BCA

ASSESSMENT REPORT

PROJECT:	10 London Street & 43 North Parade Campsie NSW 2194
STAGE:	Development Application Phase
REFERENCE:	24158.2-BCA
DATE:	17 April 2026
CLIENT:	ARADA Development Management Pty Ltd ('Arada')

Sheet title
GROUND FLOOR

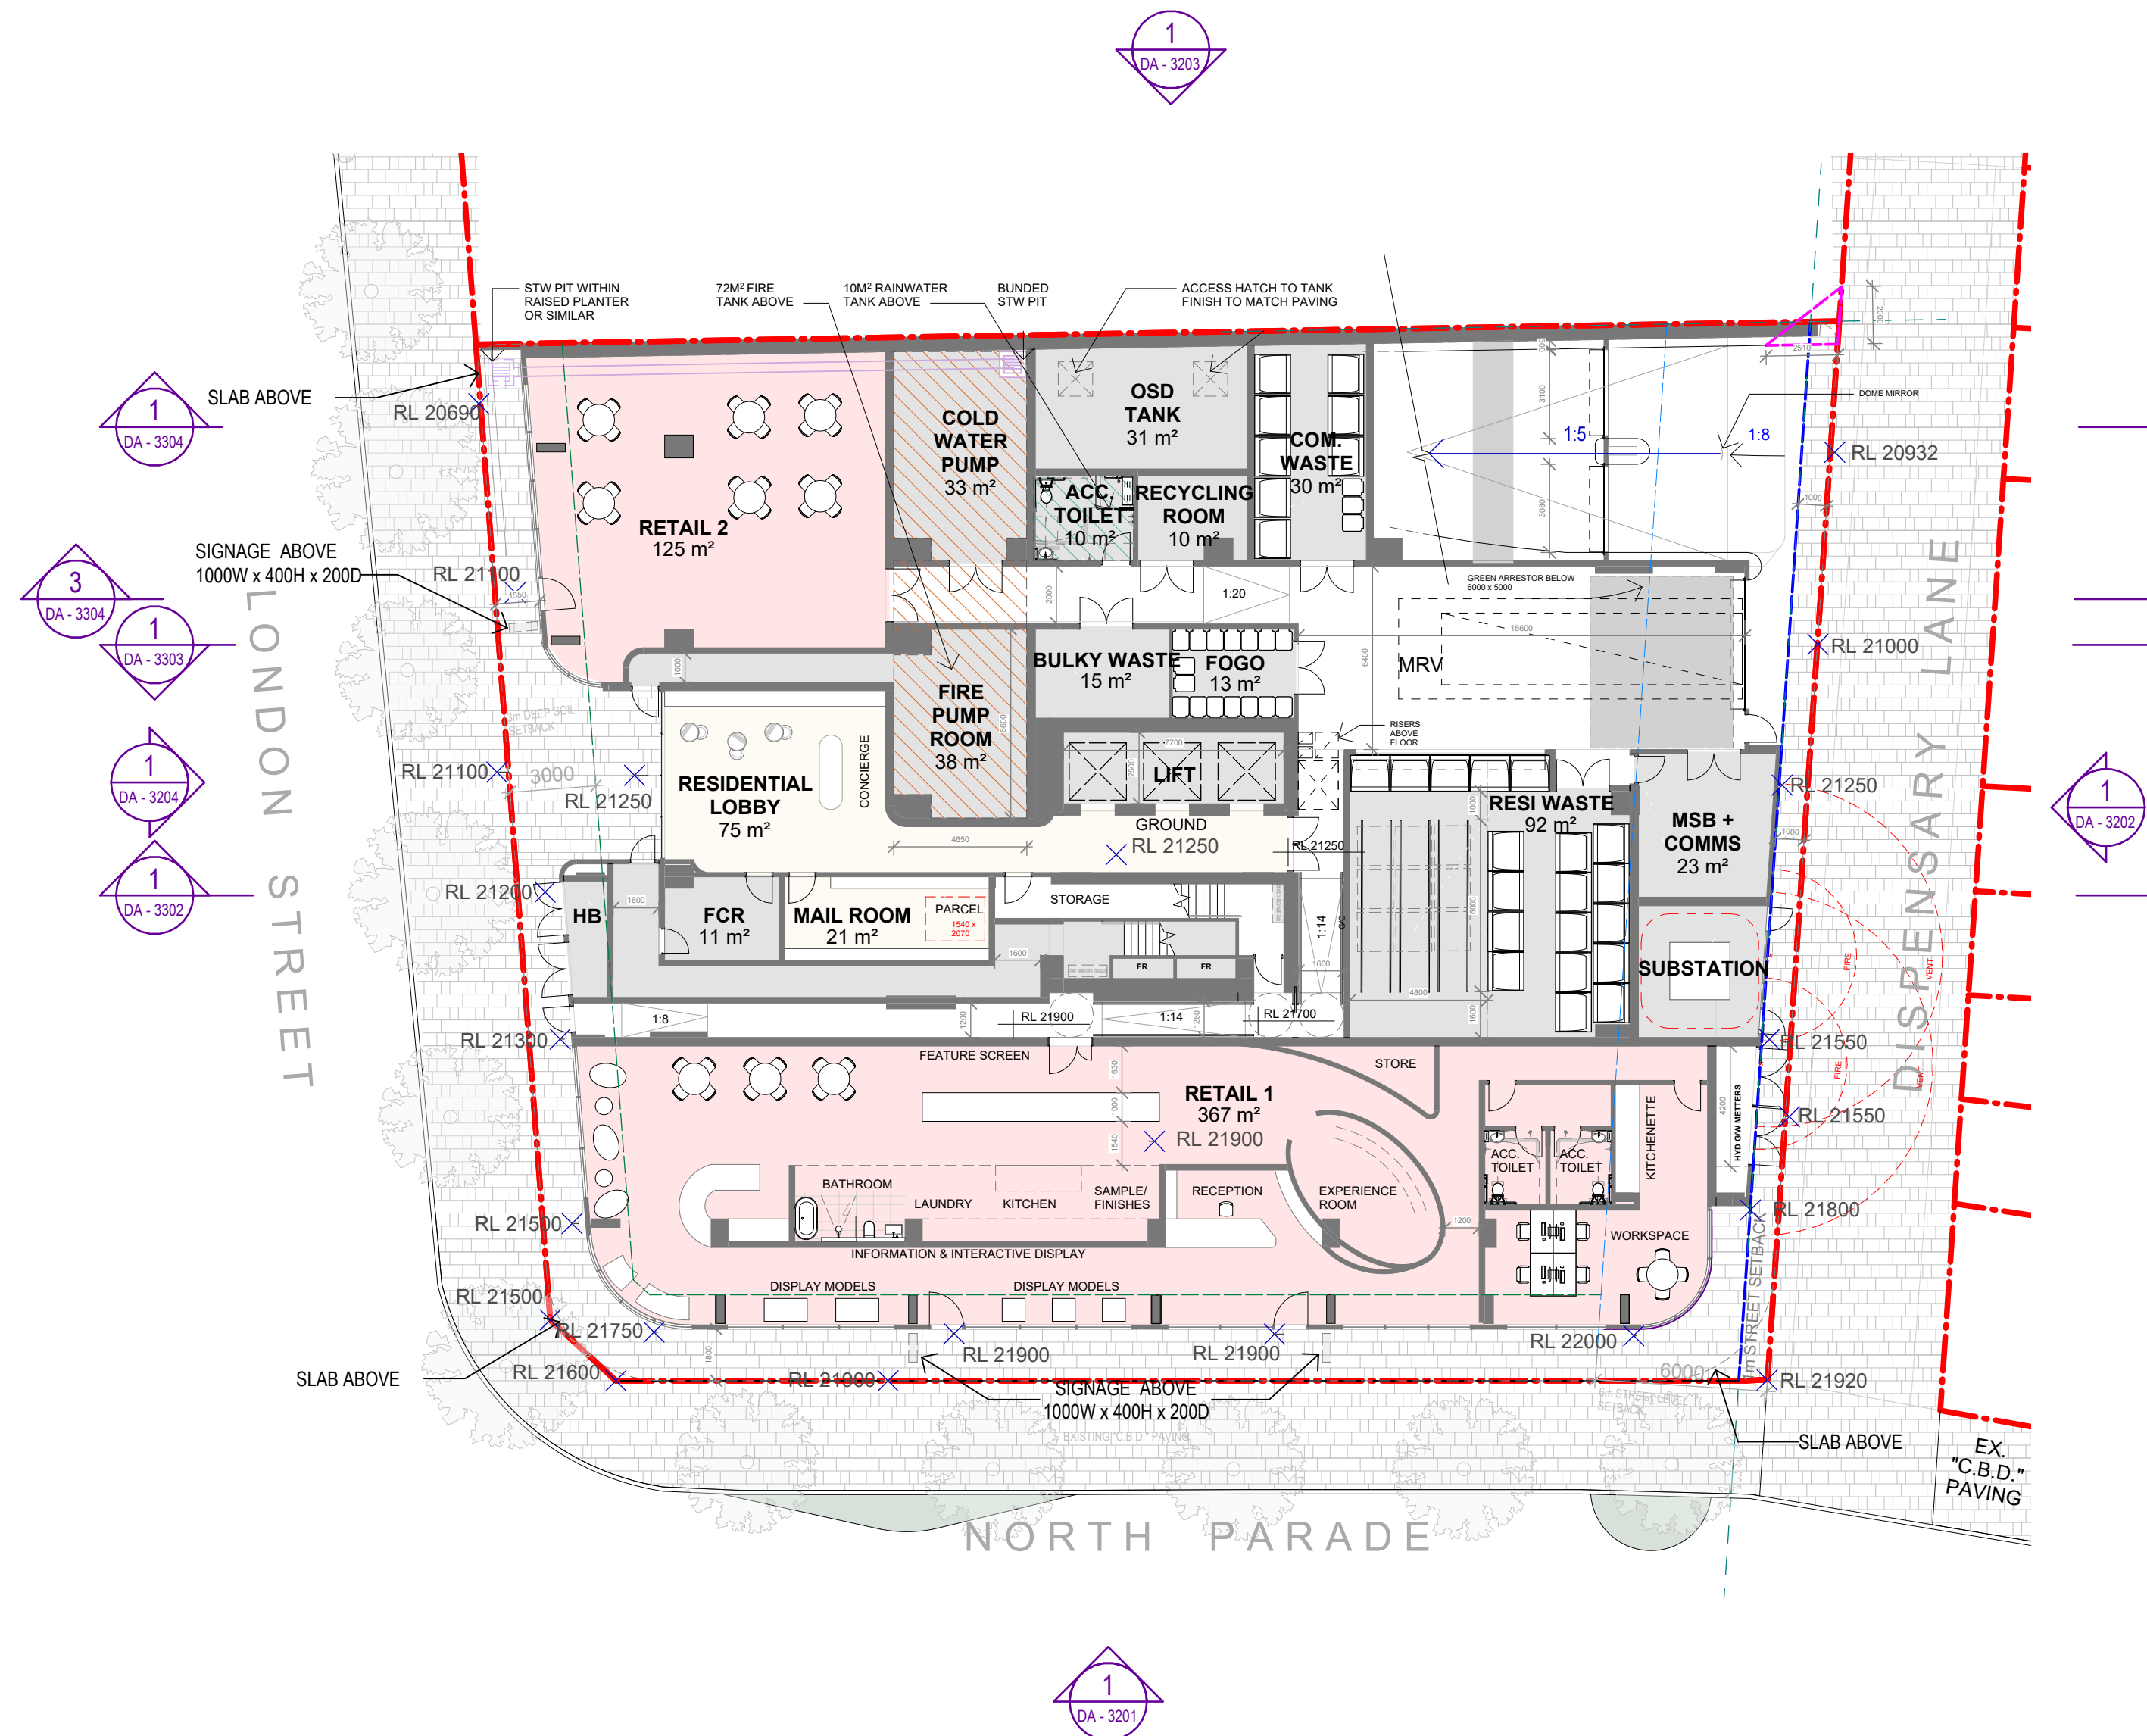
6.	D3D24	The doorway opening into the fire isolated exit on the ground floor is identified as being fitted with a sliding door.	The subject doorway is to be replaced with a swing door that is a self closing or automatic closing --/60/30 fire door.

Item	BCA Clause	Issue	Recommendation/s for resolution
7.	D3D25	The swing doors serving as required exits from the Retail 1 tenancy are identified as swinging against the direction of egress.	The following options are recommended – (a) Reconfigure the proposed layout so that the subject doors swing in the direction of egress; OR (b) Justify the direction of swing doors via a Performance Solution prepared in accordance with A2G2 of the BCA, at the Construction Certificate stage.

3 SECTION THROUGH WASTE ROOM
SCALE 1 : 100

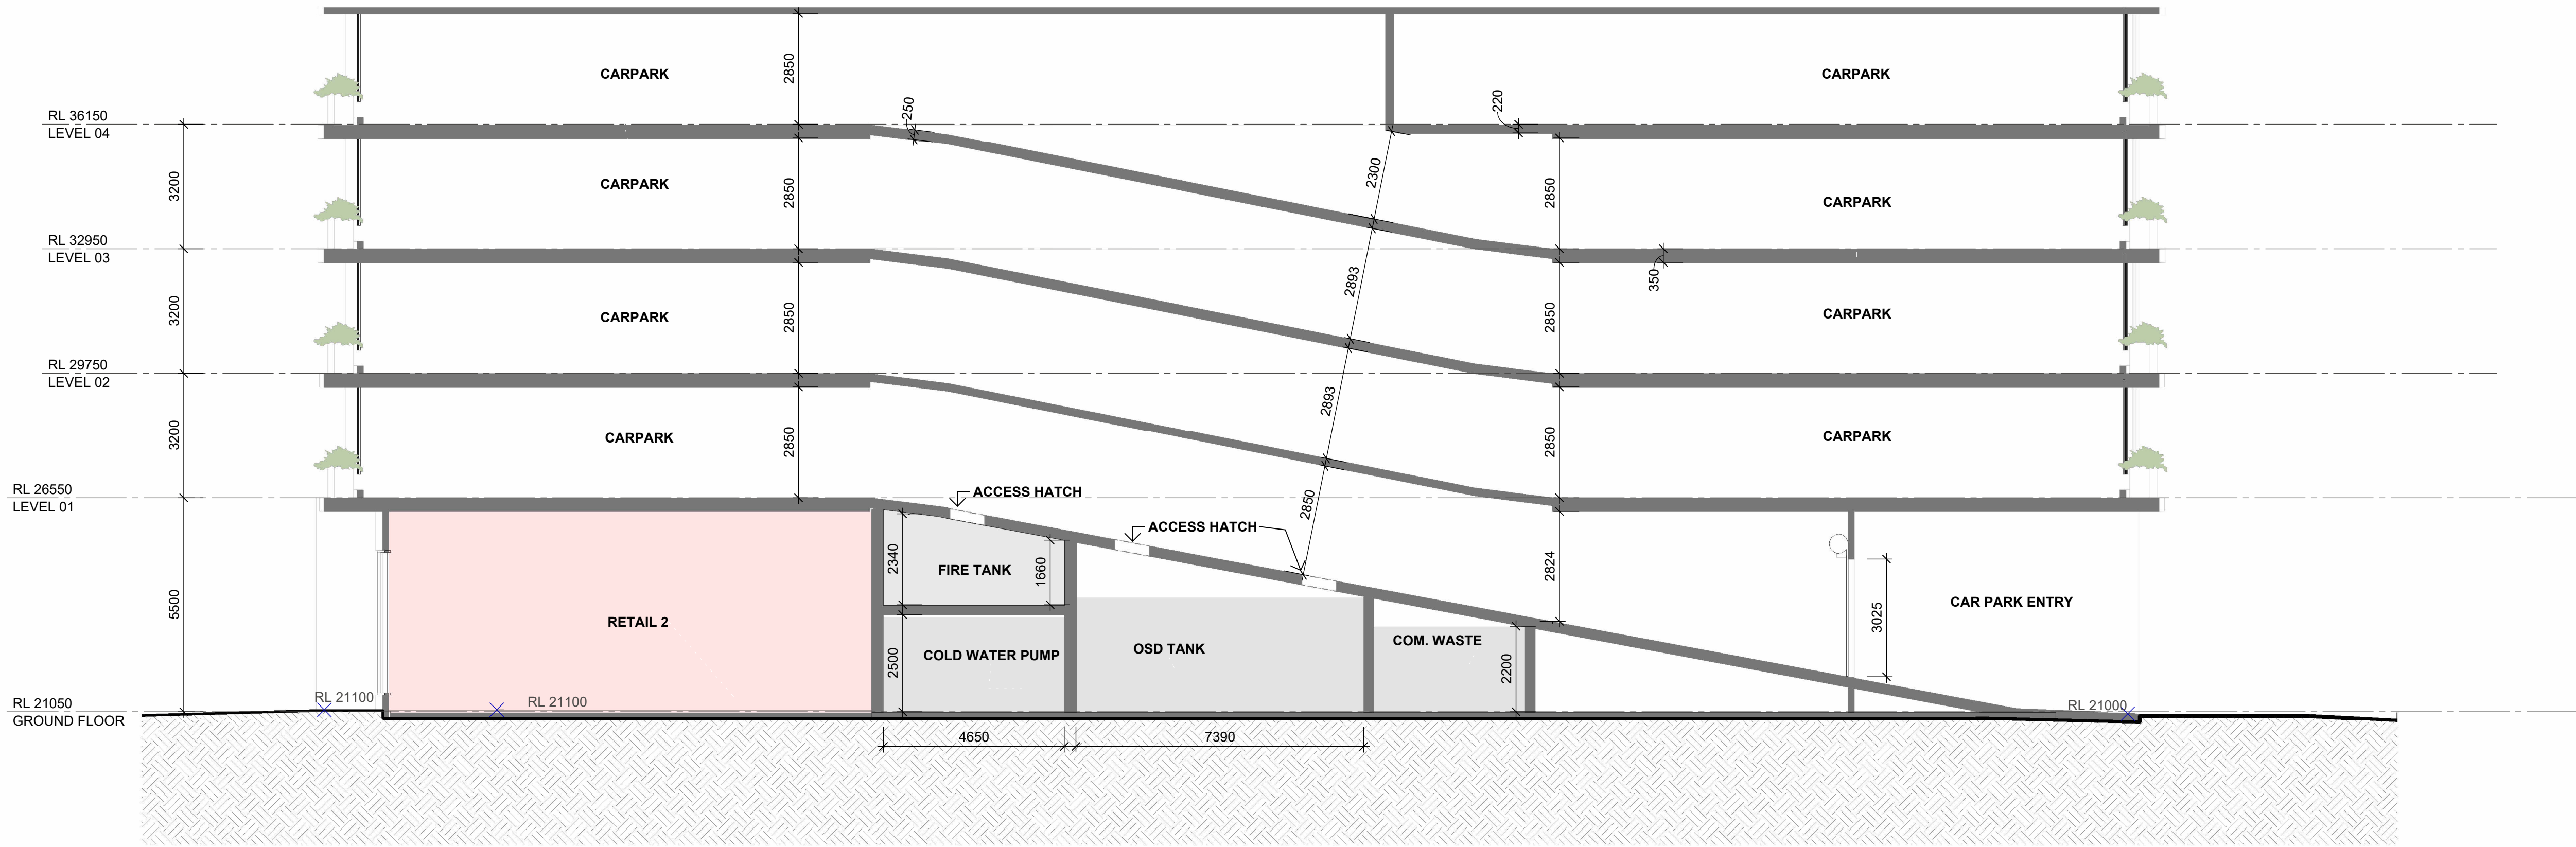
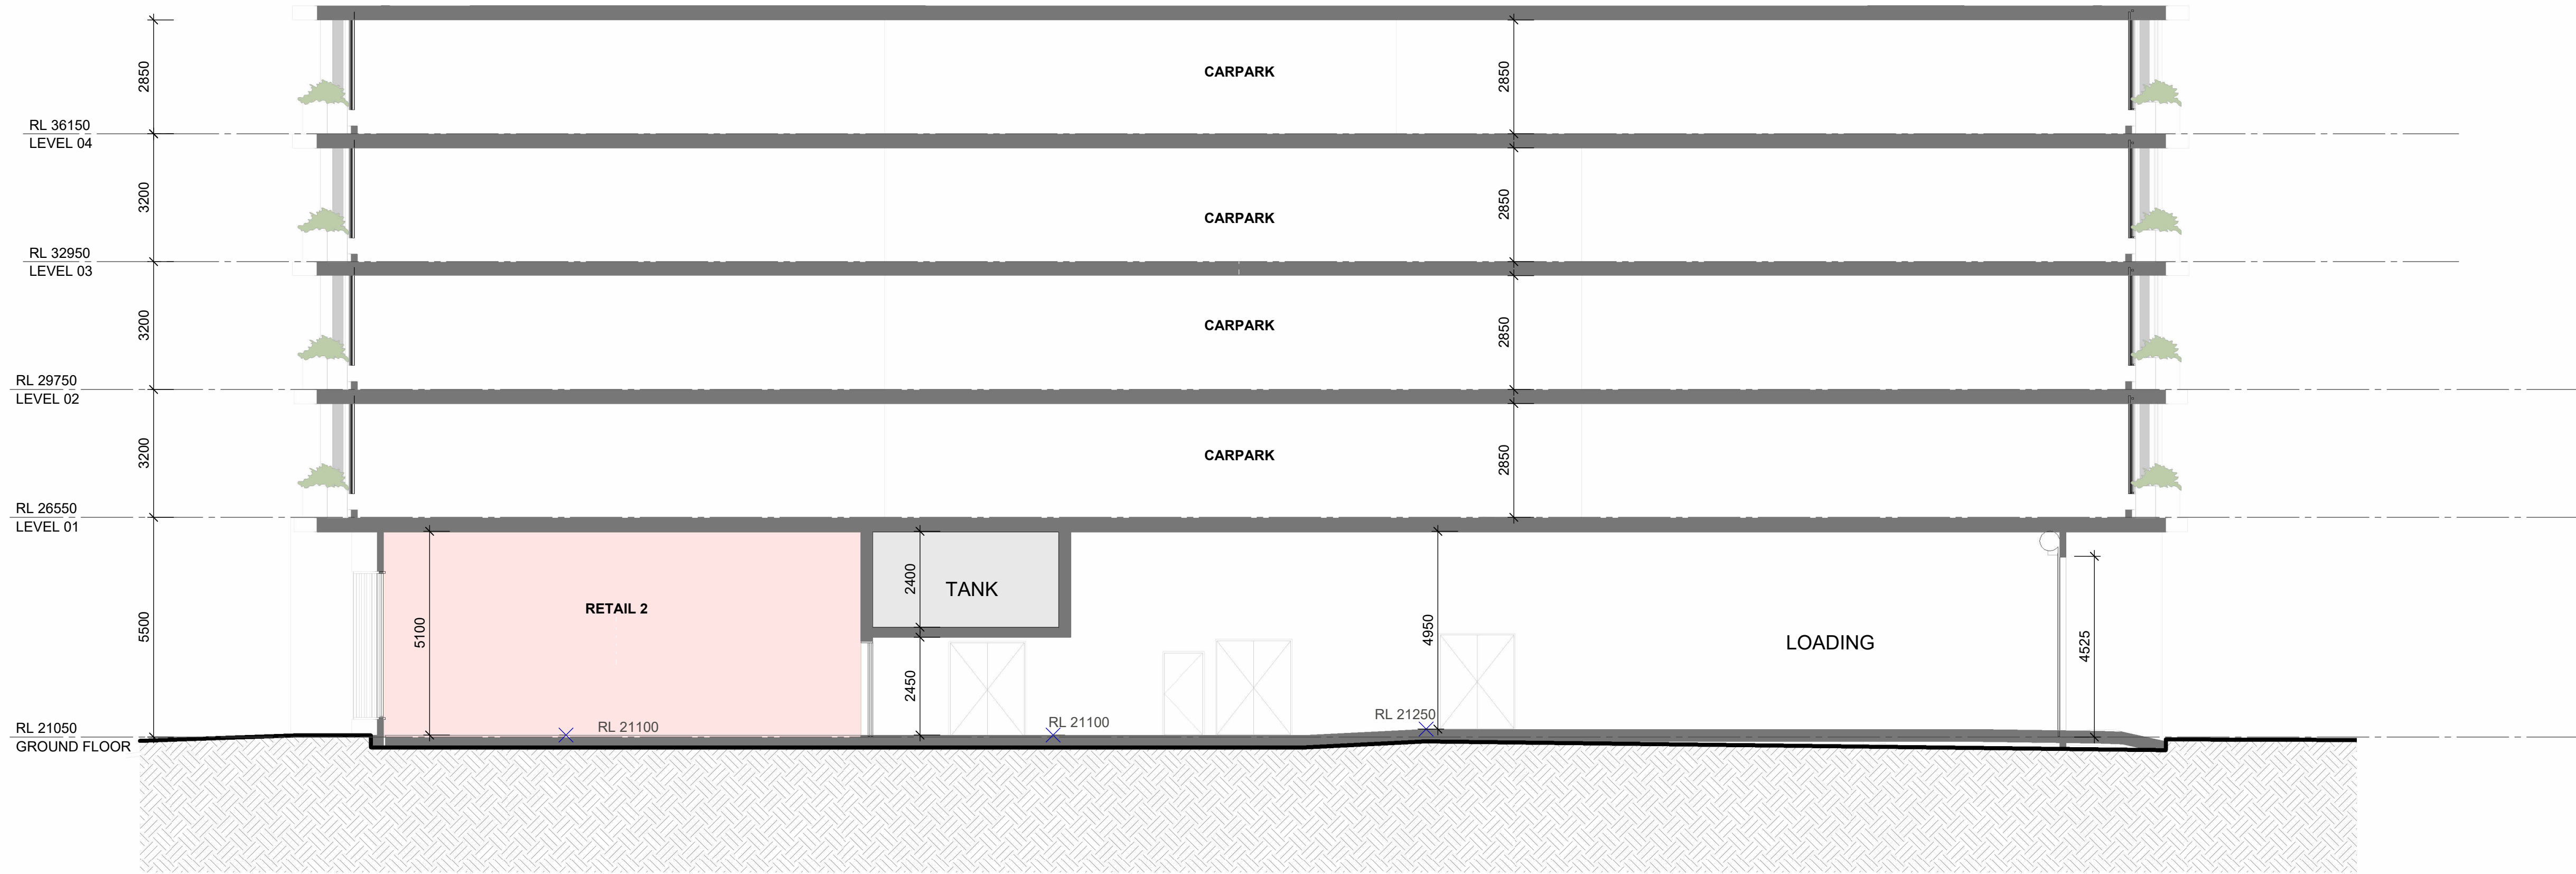
Item	BCA Clause	Issue	Recommendation/s for resolution
1.	C2D2 & Specification 5	The garbage chute shafts discharging into the residential waste room are proposed to be unenclosed at the bottom in lieu of being laid directly to the ground.	It is understood the proposed configuration of the garbage chute shafts is addressed via a Performance Solution prepared in accordance with A2G2 of the BCA, at the Construction Certificate stage.
